# CITY OF ALBUQUERQUE

**Re: Zone 3 Grading Plan, Engineer's Stamp Date 12-03-2013**  
**Zone 4 Grading Plan, Engineer's Stamp Date 12-13-2013 (M-15/D026)**

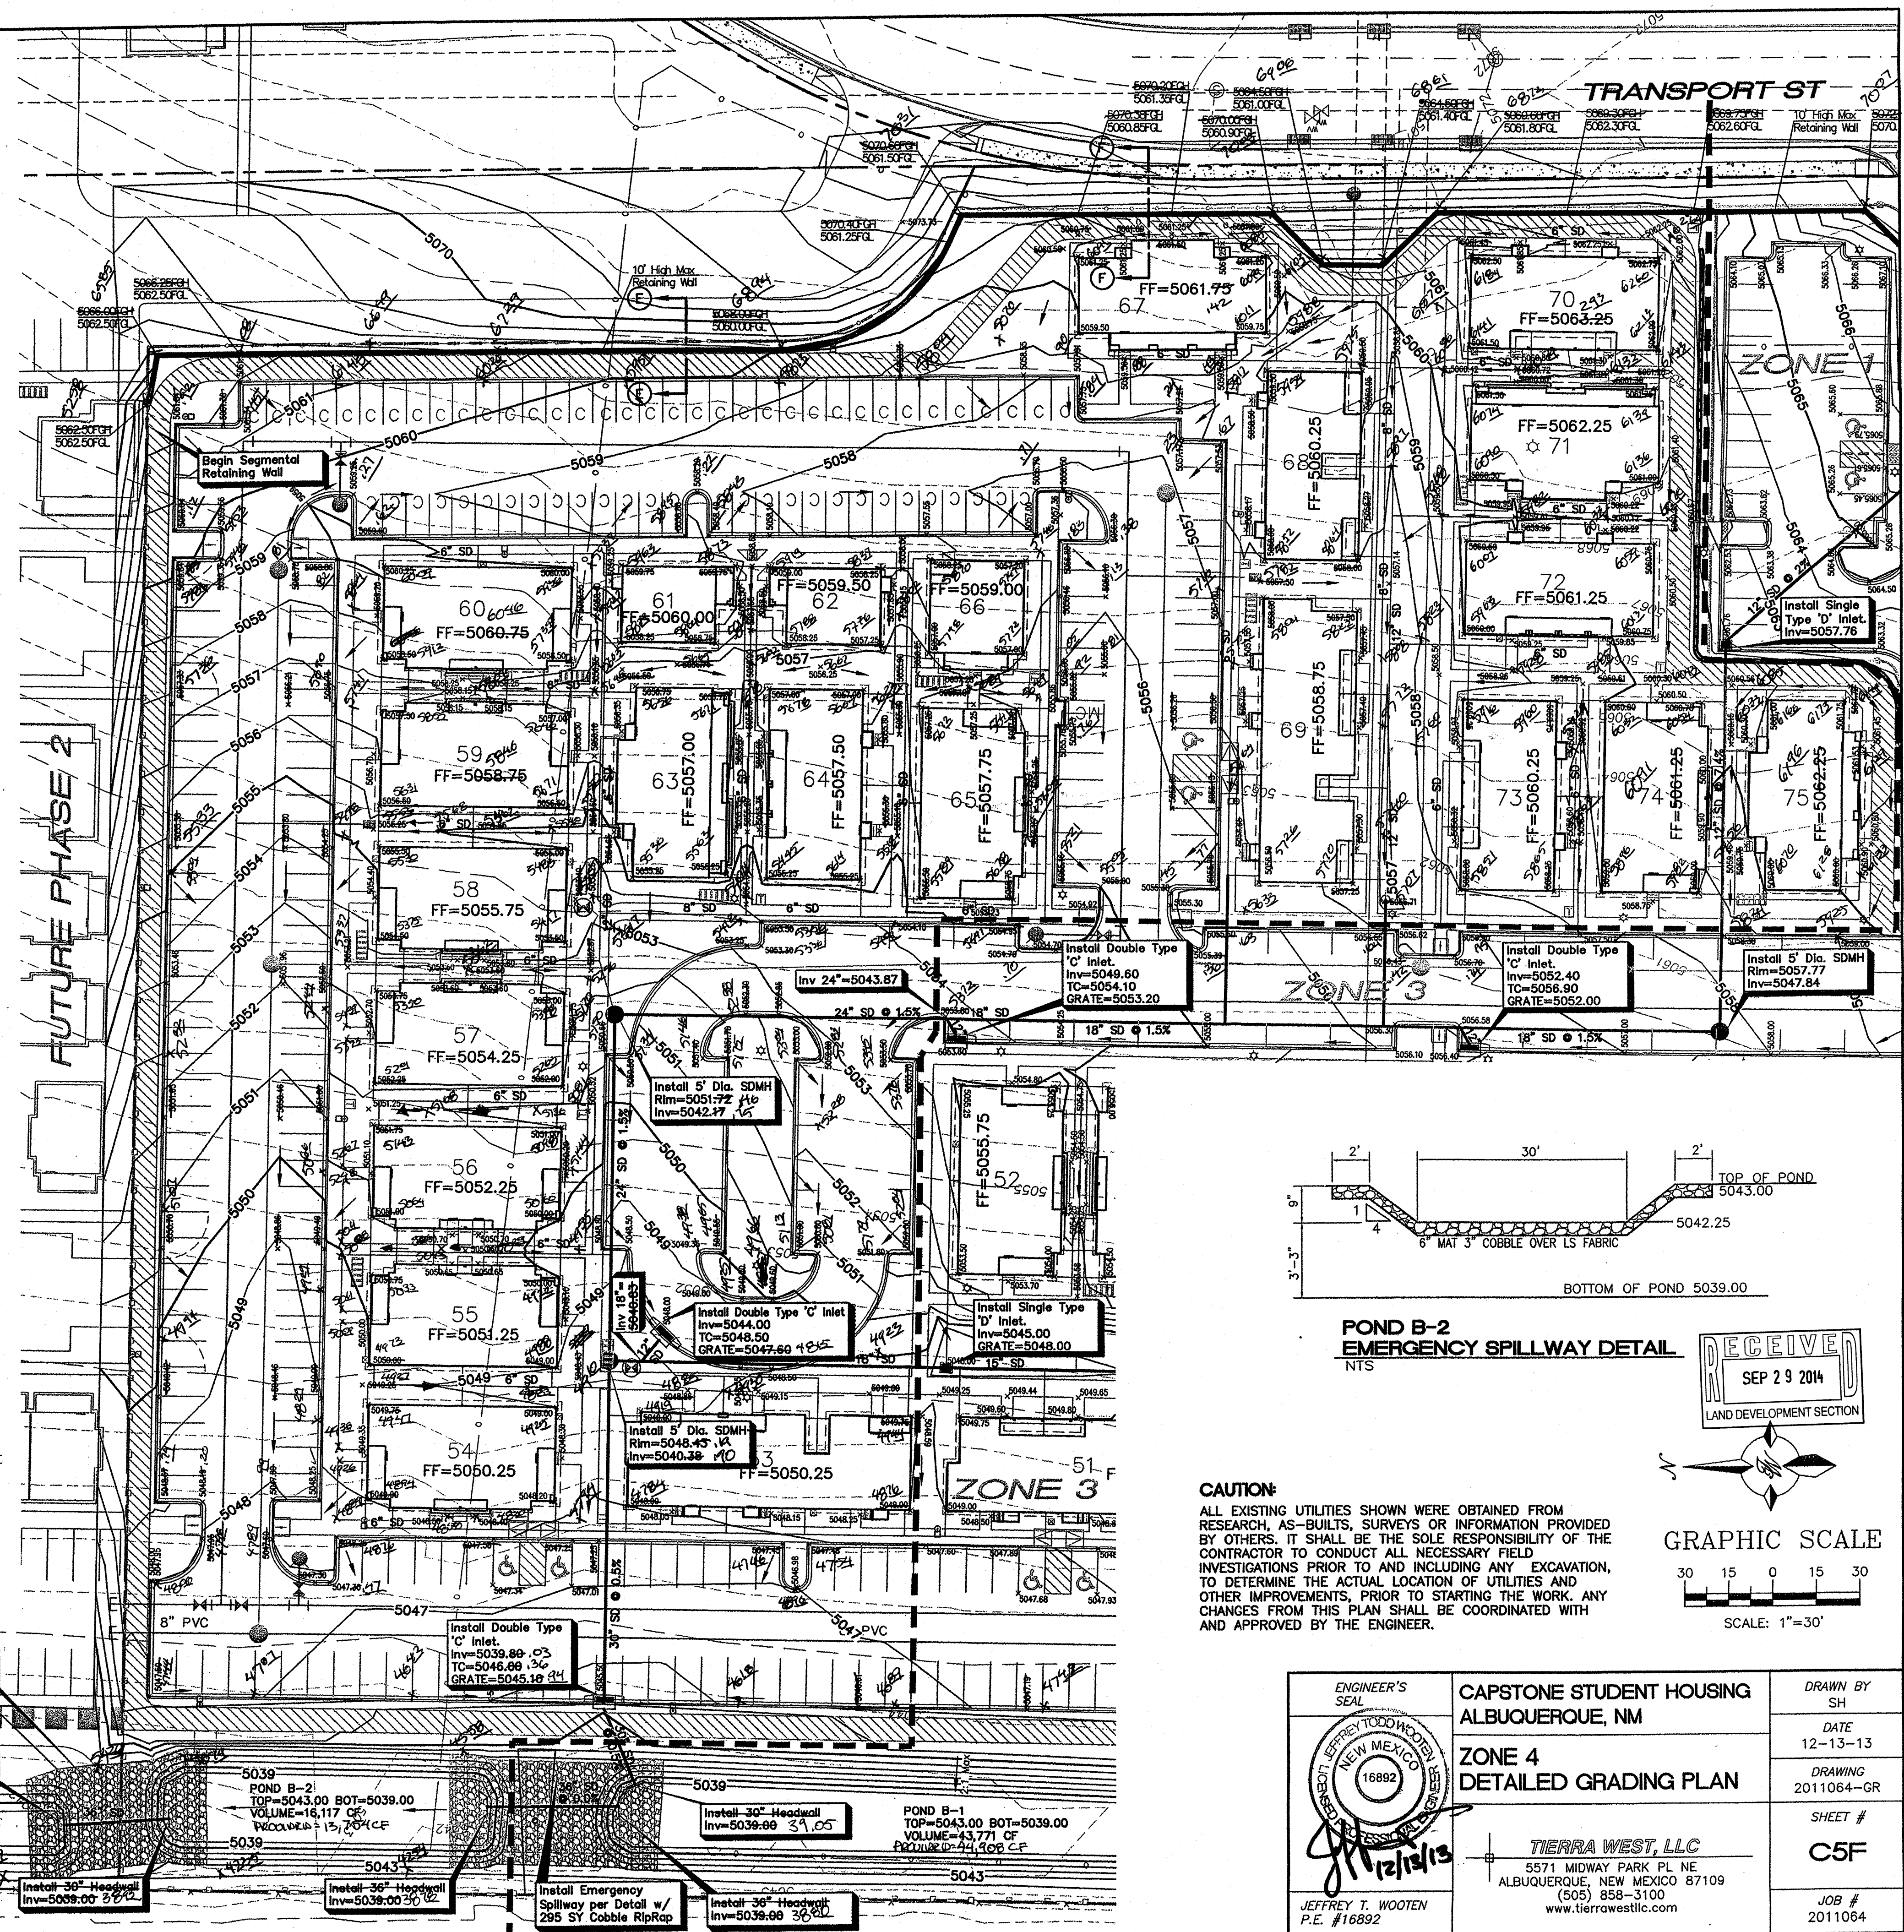
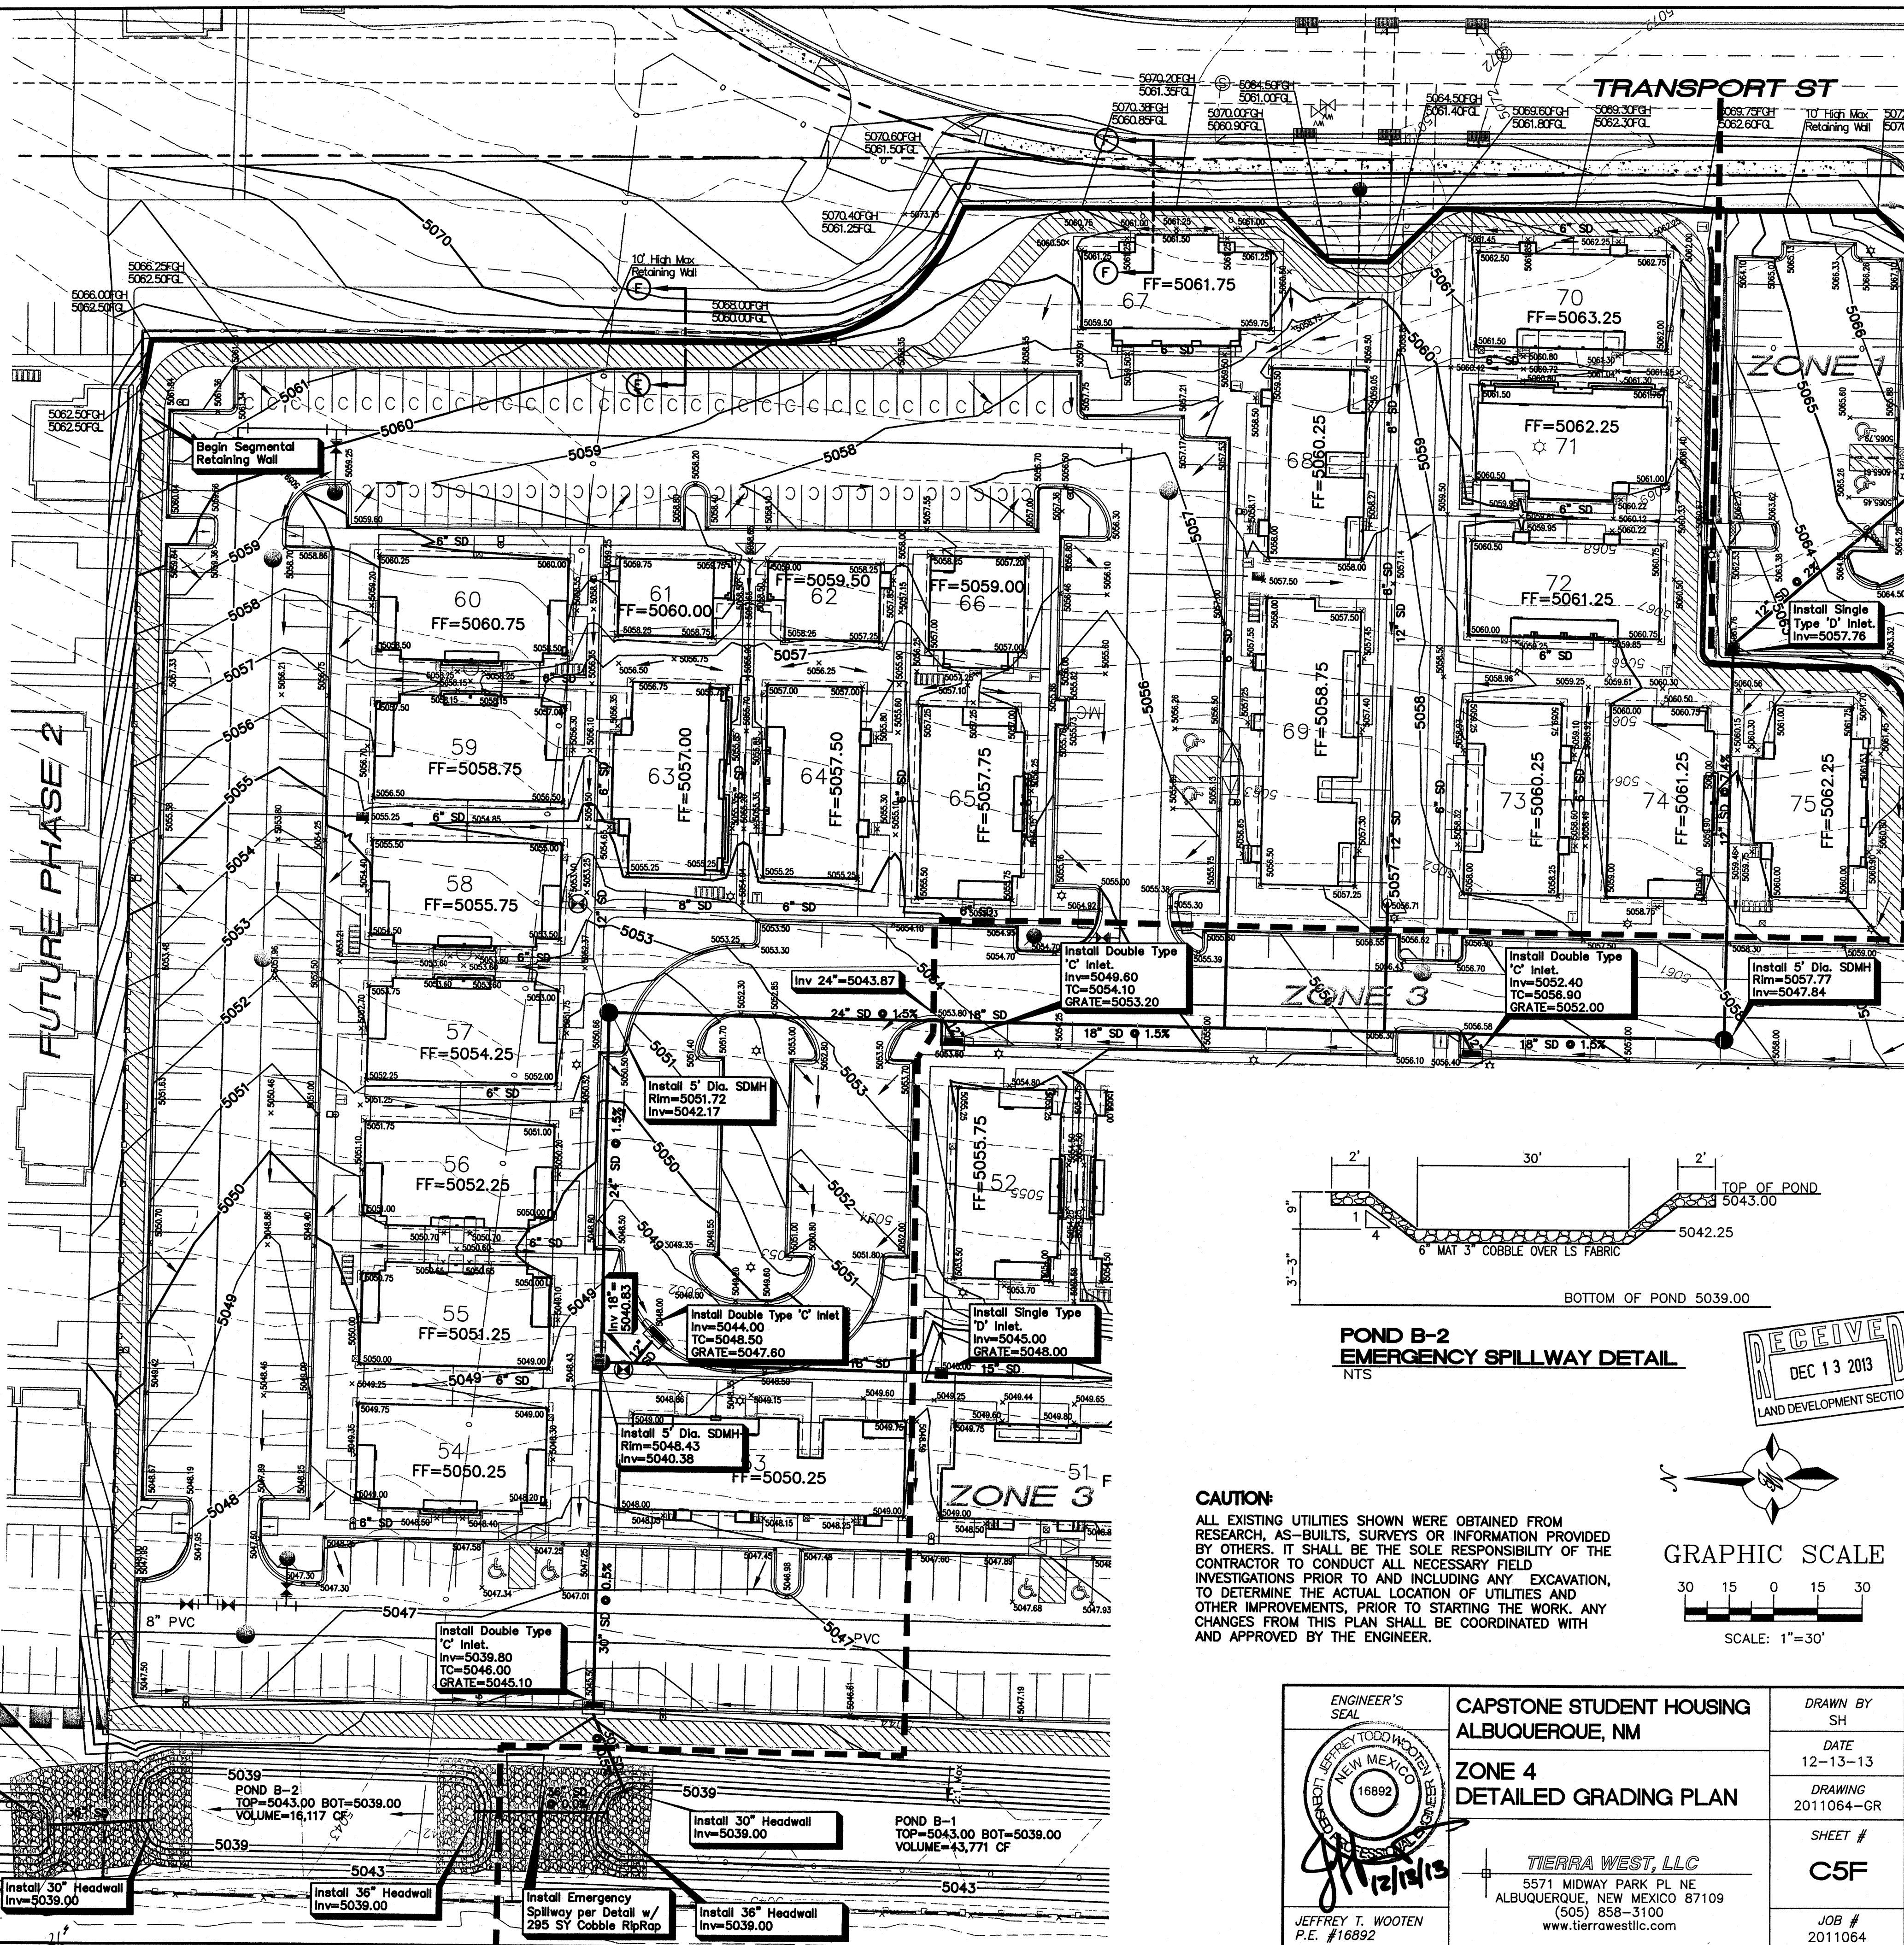
- 30" headerwall should be change to 36" headerwall for the 36" storm drain pipe connecting Pond B-2 to Pond B-3.
- When providing as-built drawings, please provide all inlet numbers, inlet/mh/storm drain pipe inverts, inlet top of curb and grate elevations, and all the storm drain pipes slopes and normal flow depths.
- As-built pond volumes should be provided.
